Subject: Exhibition – Concord Hospital Multi-Storey and at-grade Carpark (SSD-9036-Mod-7)

Thank you for your email received 14 December 2021 requesting comments on the above proposal. Environment, Energy and Science Group (EES) has reviewed the submitted documents and provides its recommendations and comments below.

DRAWING No.  
MSCP-LS-DRG-000

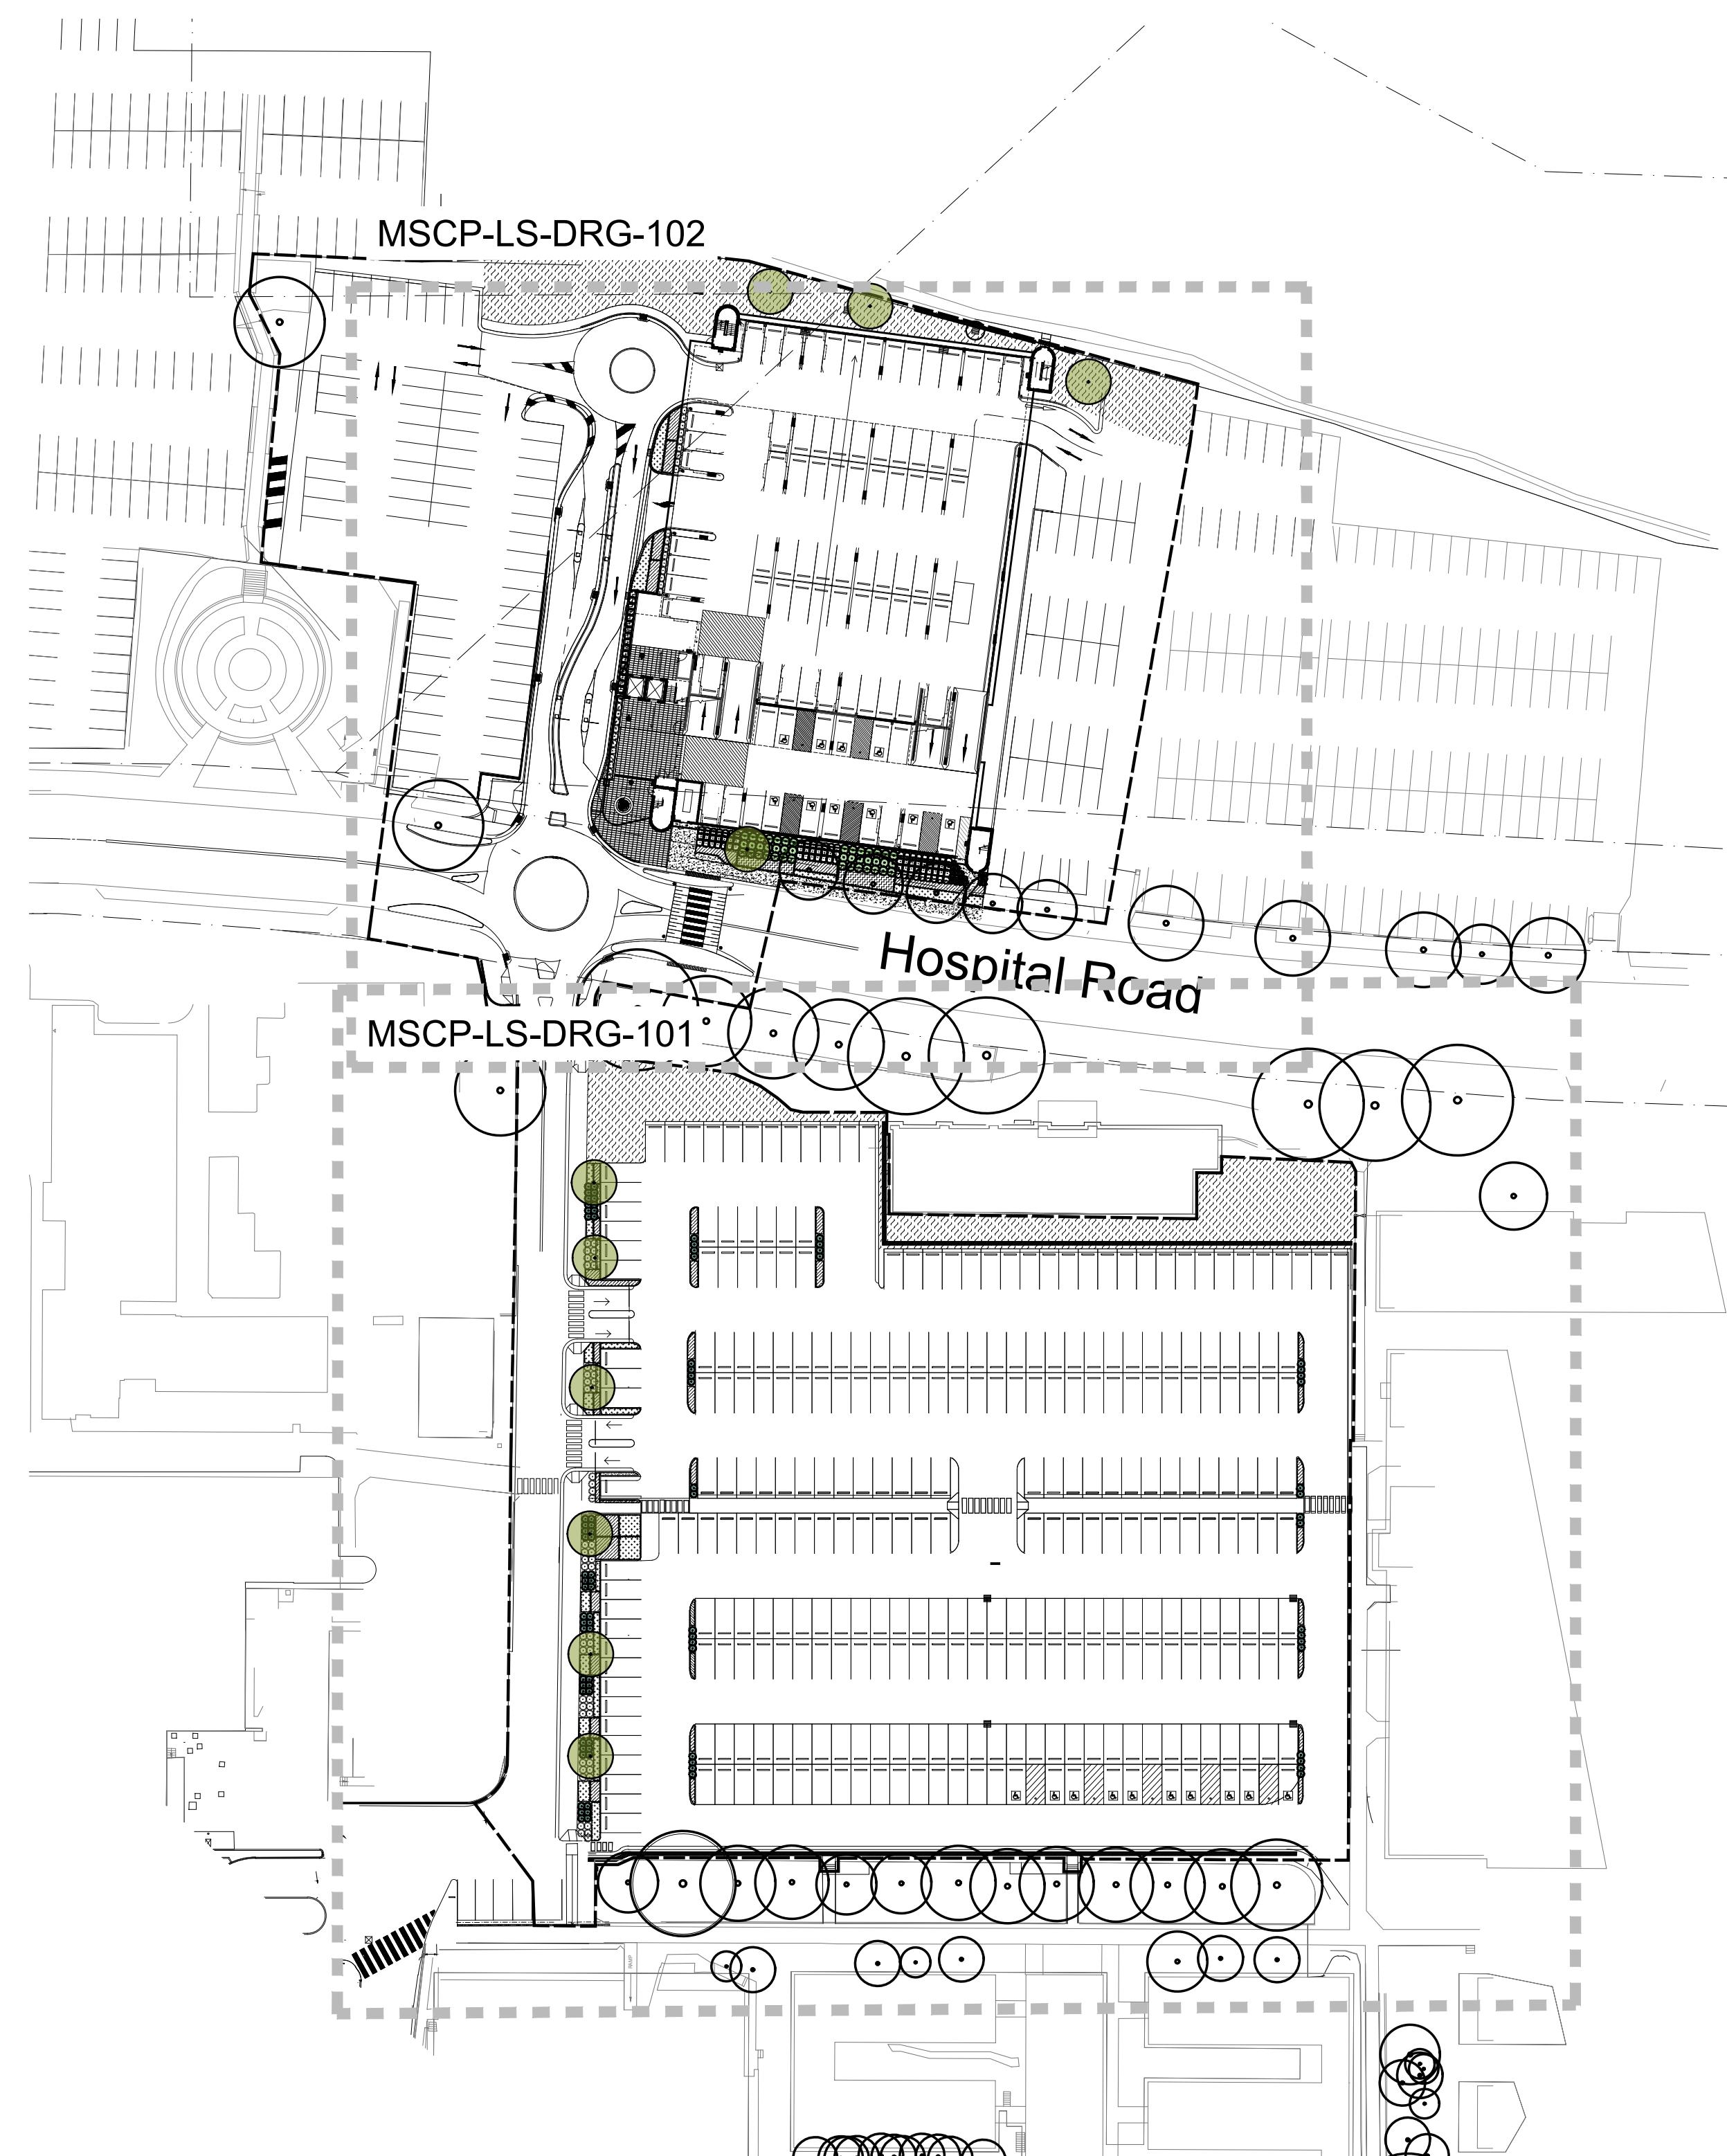
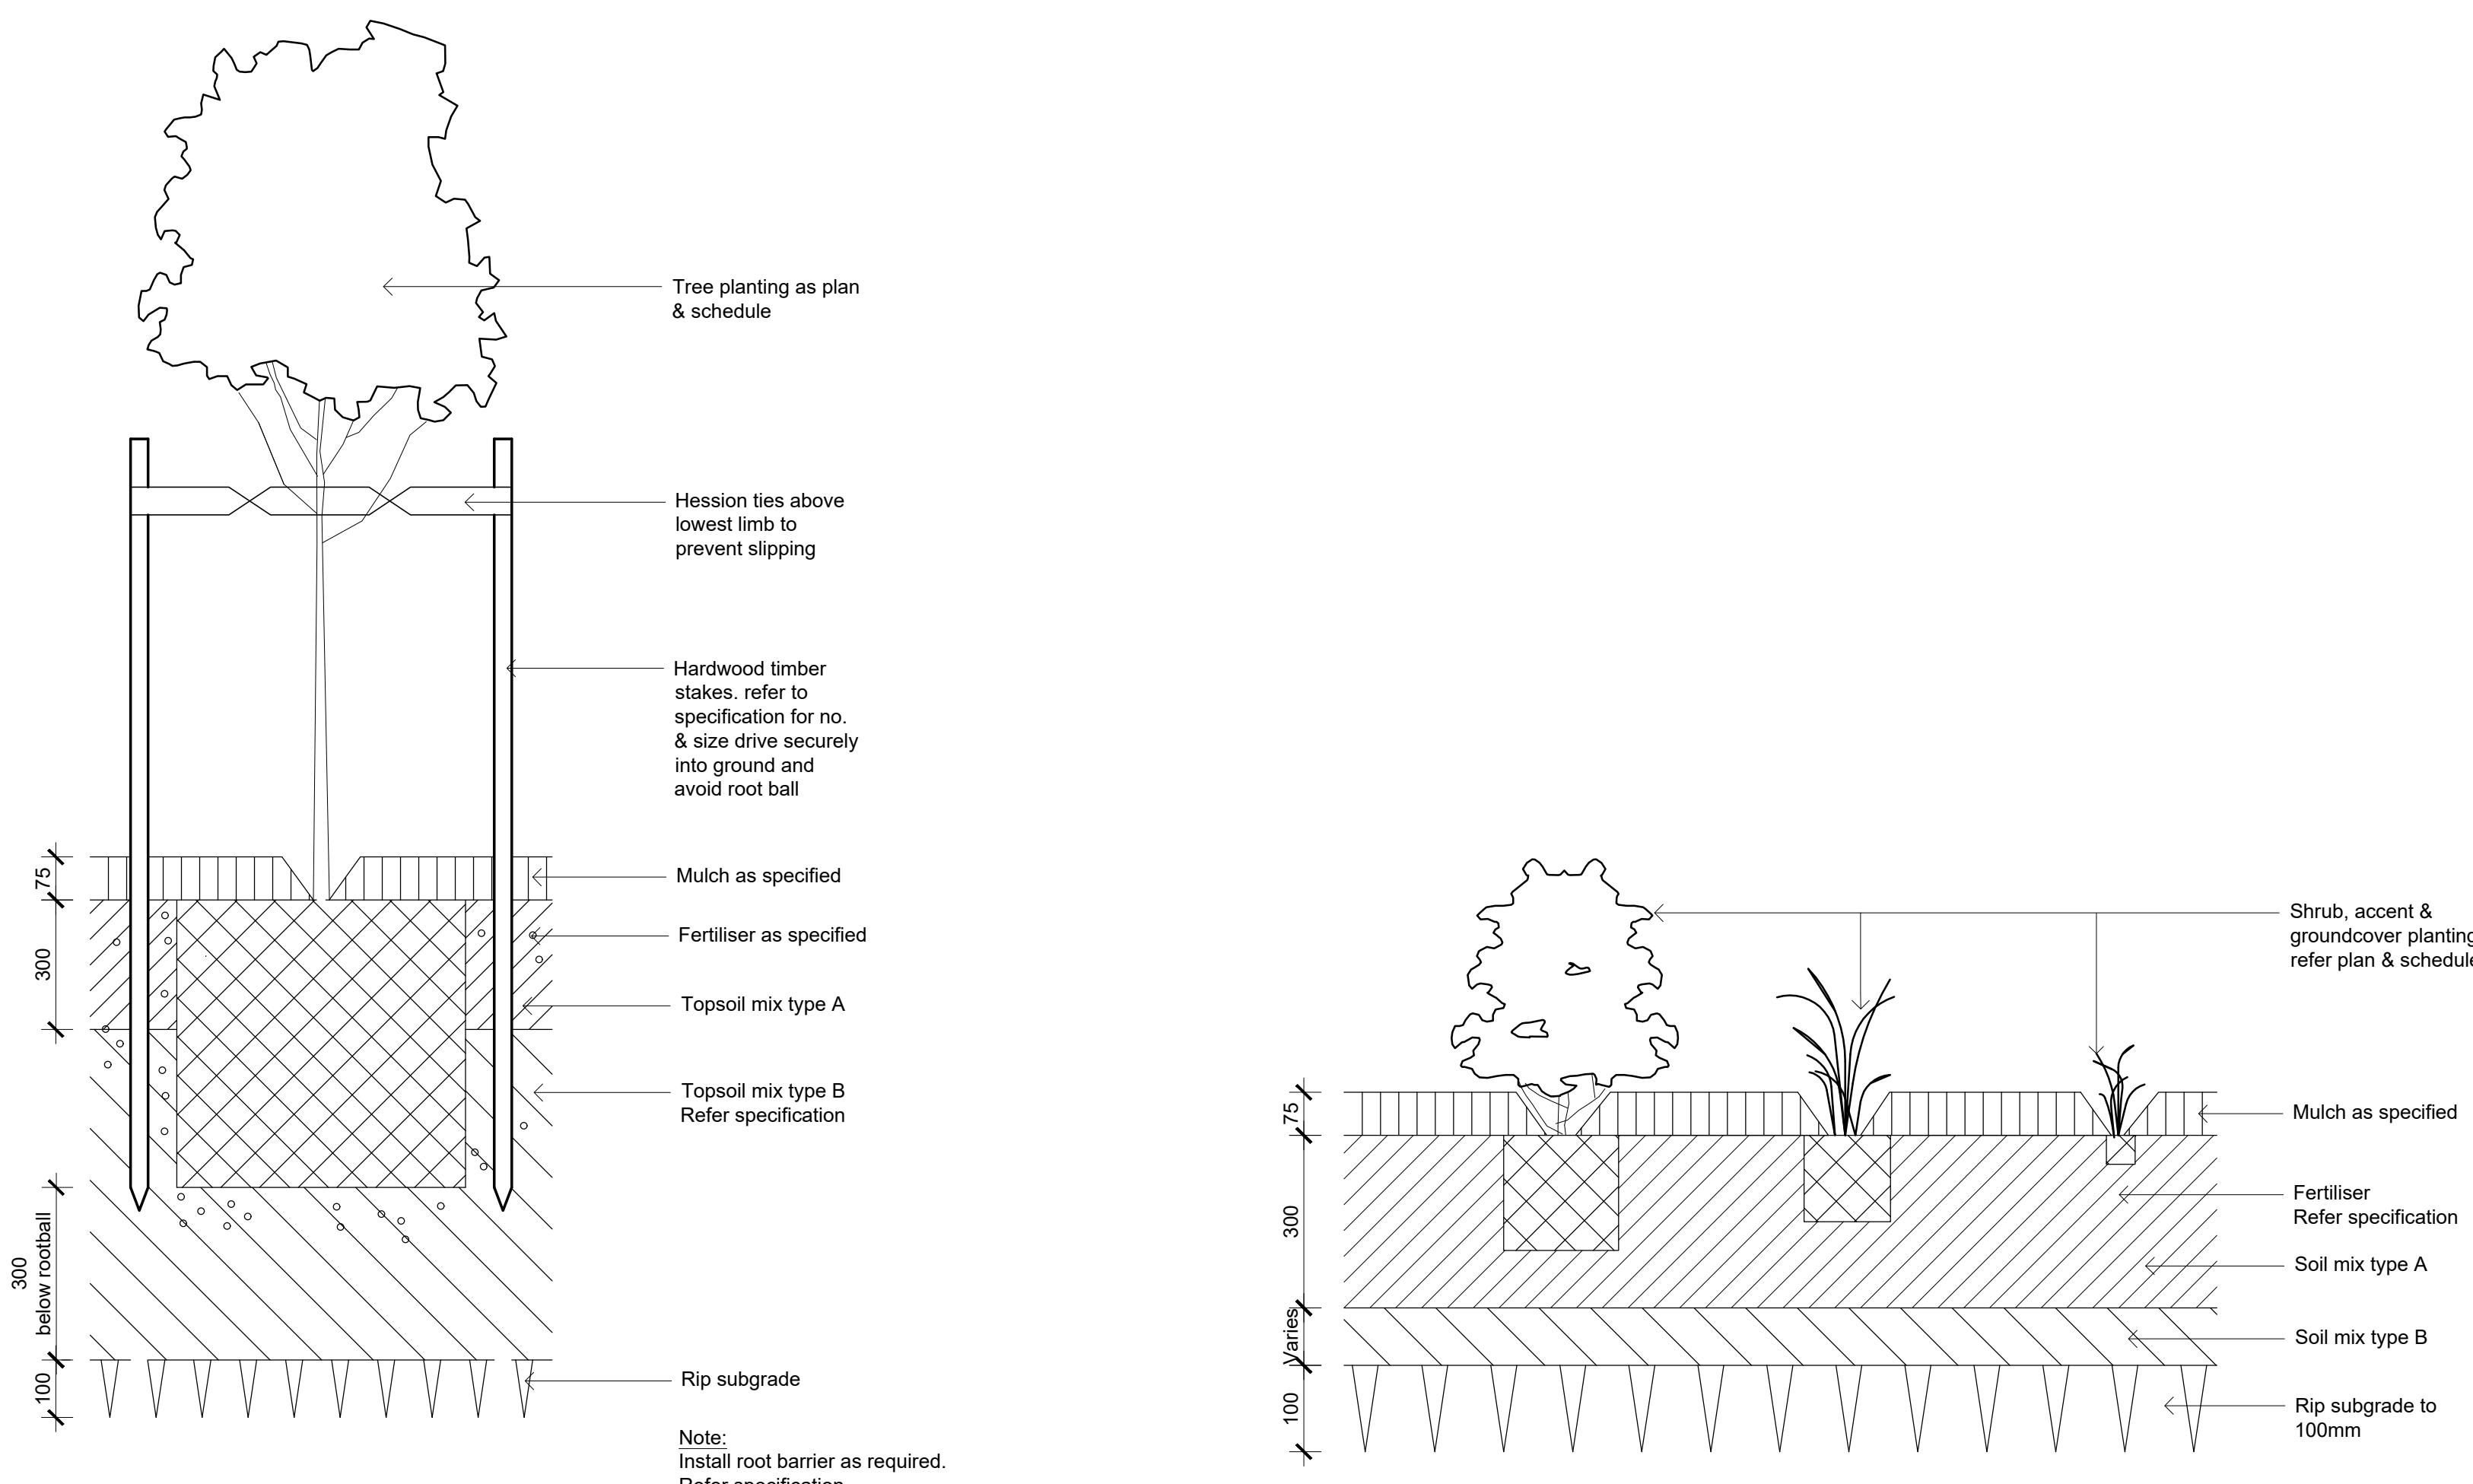
EES notes that the applicant has committed to replace these trees at a 1:1 ratio. EES recommends that trees removed by the project should be replaced at a ratio greater than 1:1 to mitigate the local urban heat island effect and improve local biodiversity over time. It is proposed to address the removal of the trees in the Revised Landscape Plans prepared by Site Image.

EES recommends that the applicant in the Response to Submission (RtS) proposes an amended condition which accounts for the additional trees to be removed by Mod 7, or a new similar condition specifically for MSCP and that the ratio for replacement be greater than 1:1. EES agrees with the requirement that the minimum pot size be 75 litres.

EES usually recommends that the landscape planting uses a diversity of local provenance native species from the relevant native vegetation community or communities that occur, or once occurred on the site rather than use exotic species or non-local native species. However, given the built-up character of the site and the existing conditions of consent relating to landscaping, EES would agree to other species being used in consultation with the Council. EES recommends that the RtS confirm that none of the species proposed for landscaping at the site have the potential to become weeds.
